Our ref: DOC20/531505

Senders ref: SSD10365

Subject: Notice of Exhibition – St Francis Catholic College Landscaping Plan (SSD 10365)

01 NATIVE GRASSES + GROUNDCOVER MATRIX - 5m x 5m  
SCALE 1:50

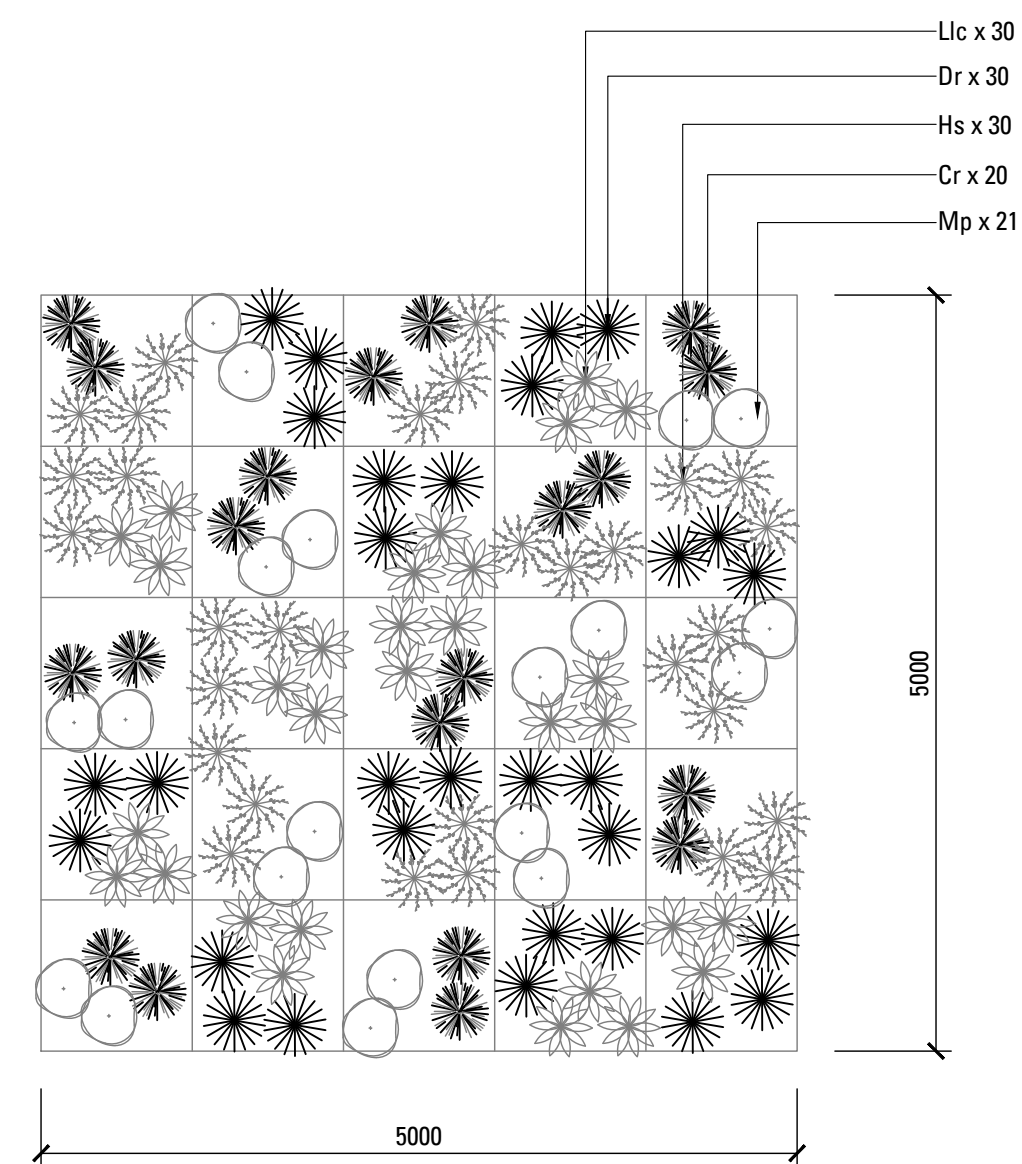
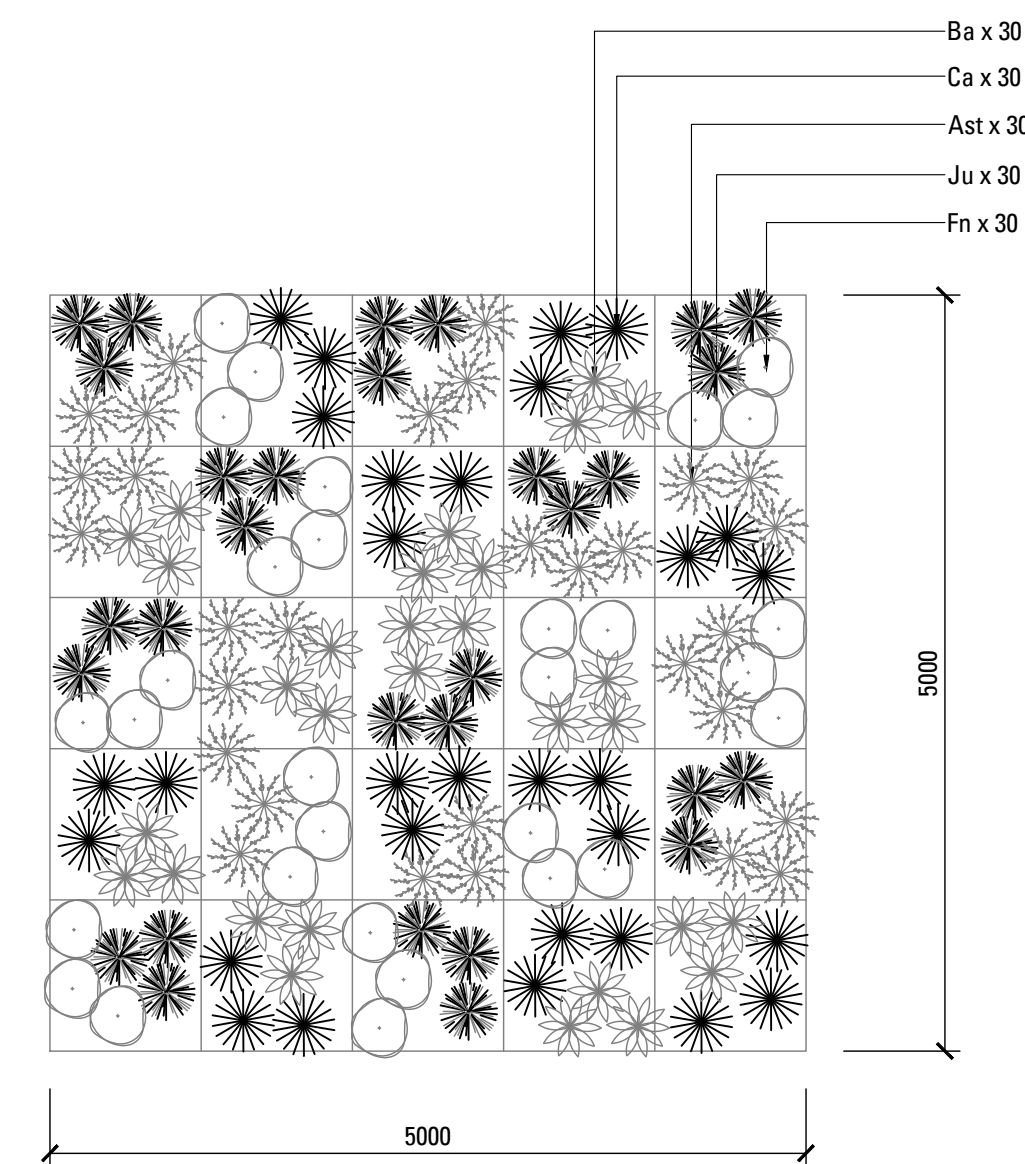
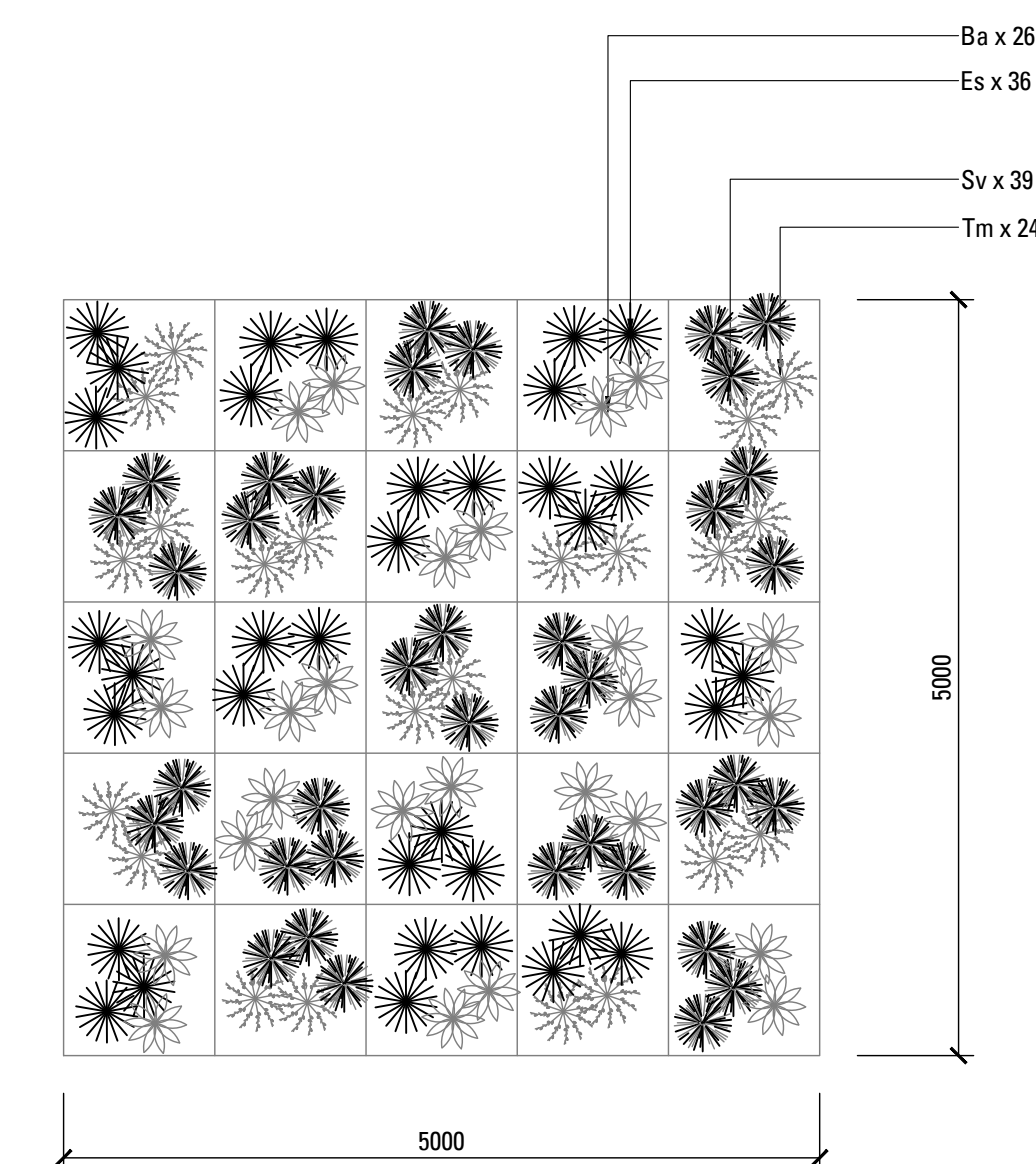
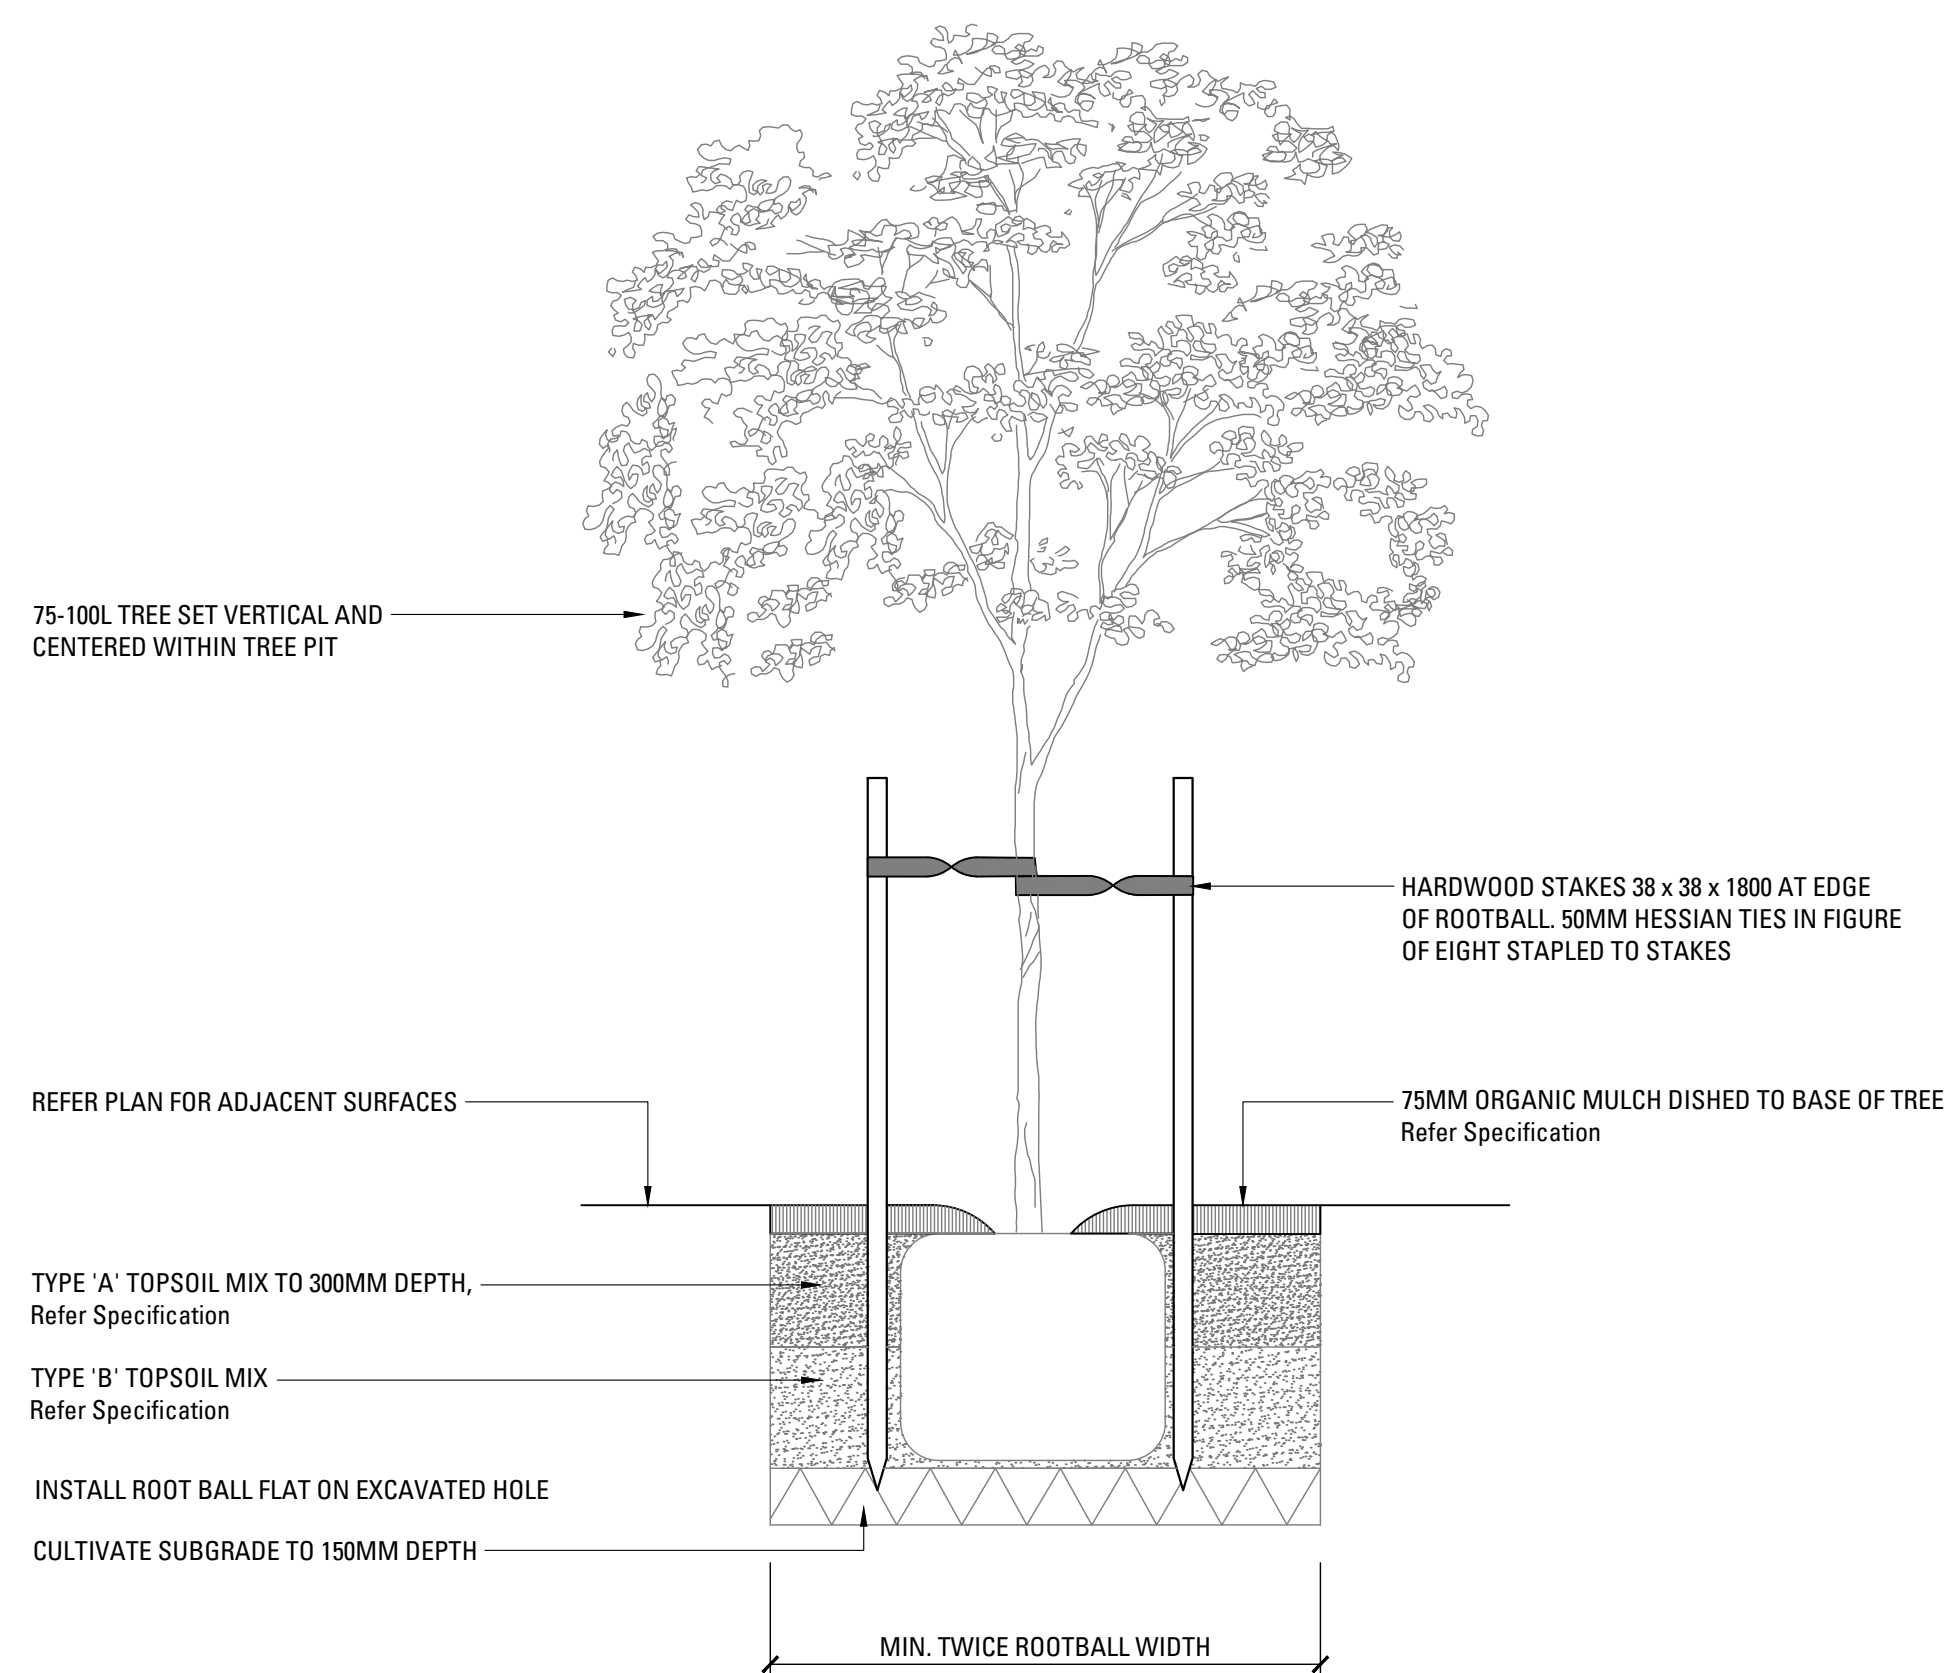
However, EES notes that the planting schedule in the Landscape Management Plan includes several species not found in these vegetation communities. In order to meet the SEARs requirements, EES recommends the planting schedule is amended to include the following species (as per EES's BioNet Vegetation Classification database):

1. In areas where SPW would have occurred on site, appropriate species for planting are:
Eucalyptus moluccana, *E. tereticornis*, *Bursaria spinosa*, *Dichondra repens*; *Cheilanthes sieberi* subsp. *sieberi*; *Aristida vagans*; *Microlaena stipoides* var. *stipoides*; *Themeda australis*; *Brunoniella australis*; *Desmodium gunnii*; *Opercularia diphylla*; *Wahlenbergia gracilis*; *Dichelachne micrantha*; *Paspalidium distans*; *Eragrostis leptostachya*; *Lomandra multiflora*; *Dianella longifolia*; *Oxalis perennans*; *Euchiton sphaericus*; *Goodenia hederacea*; *Aristida ramosa*; *Arthropodium milleflorum*; *Austrodanthonia tenuior*; *Cymbopogon refractus*; *Echinopogon caespitosus*.

2. In areas where AW would have occurred on site, appropriate species for planting are:
Eucalyptus tereticornis; *Angophora floribunda*; *Eucalyptus amplifolia* subsp. *amplifolia*, *Acacia parramattensis*; *Bursaria spinosa* subsp. *spinosa*; *Sigesbeckia orientalis*, *Microlaena stipoides* var. *stipoides*; *Oplismenus aemulus*; *Dichondra repens*; *Entolasia marginata*; *Solanum prinophyllum*; *Pratia purpurascens*; *Desmodium gunnii*; *Echinopogon ovatus*; *Commelina cyanea*; *Veronica plebeia*
